Meadow Lake Sporthorses

Vicinity Map_V1.pdf Markup Summary

Subject: Stormwater Drainage

APPENDIX 1: Project Vicinity Map

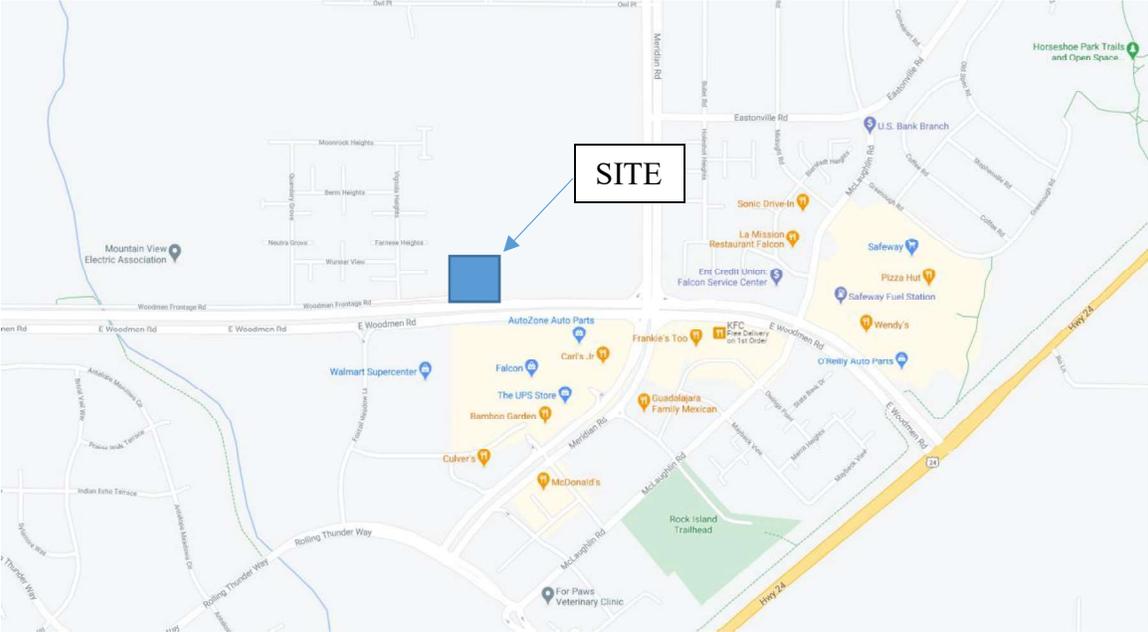
Please add scale and north arrow.
